Subject: RE: CM/52/21/DOC

Further to your call on Friday, the condition requiring boundary treatments is in respect to the western and southern boundaries highlighted yellow in the plan below.

N DISTRICT COUNCIL CM/52/21/DOC

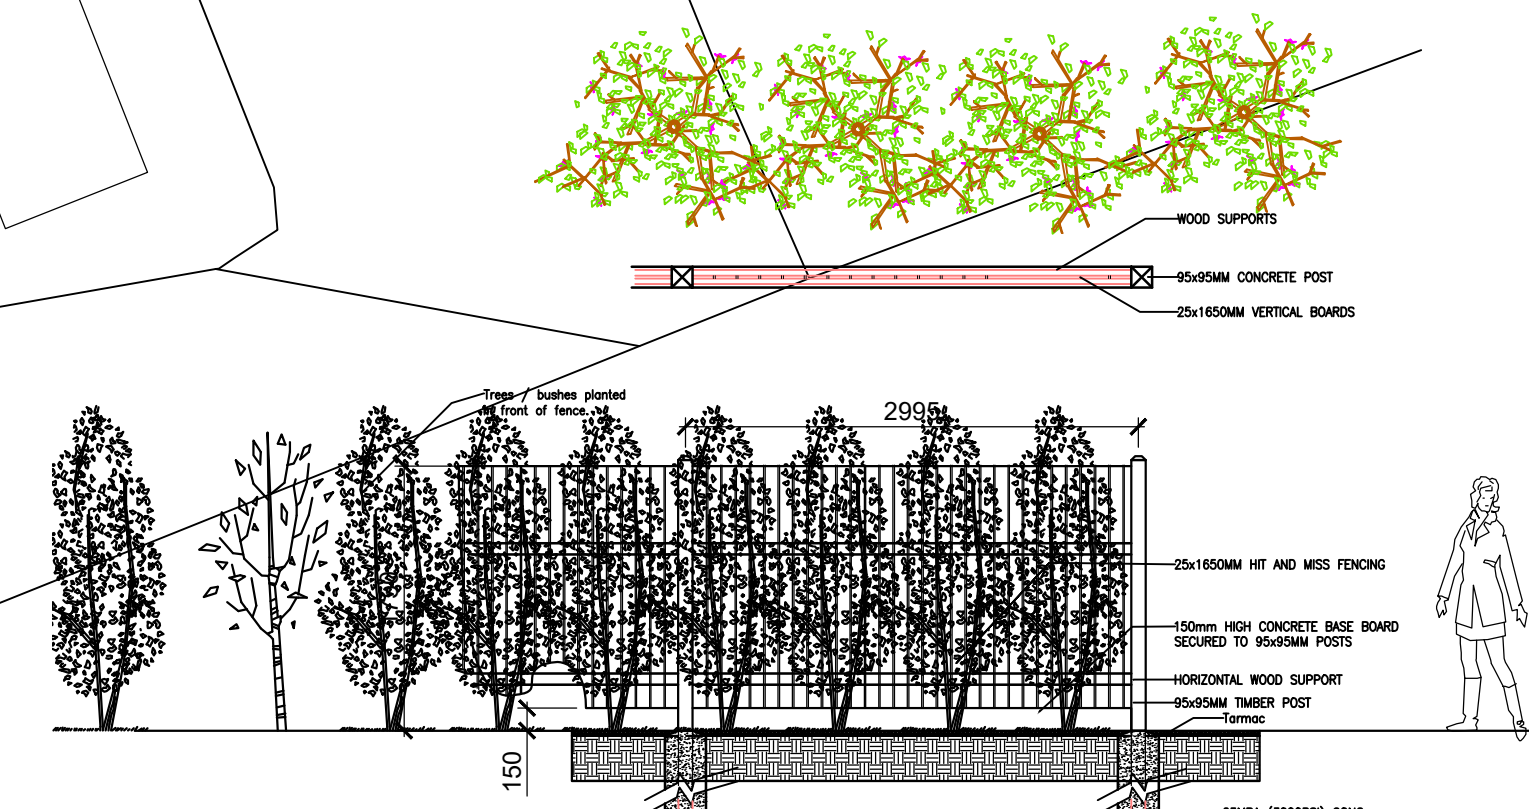
Your application shows the fencing already erected by the landowner along the western boundary which is fine. You then show a line of laurel plants along the southern boundary. There needs to be a similar style close-boarded fence along this line but you could retain the laurel plants in front of it if you wish.

Therefore what we require is an annotated block plan (suggest you annotate the approved one from the application) which indicates existing fencing along the highlighted western boundary and indicates new fencing along the highlighted southern boundary. You will need to highlight the respective boundaries like I have done (albeit more accurately) and add text to say what each of the two boundaries is. Then we will need a fencing specification for the southern boundary so we know exactly what we are approving.
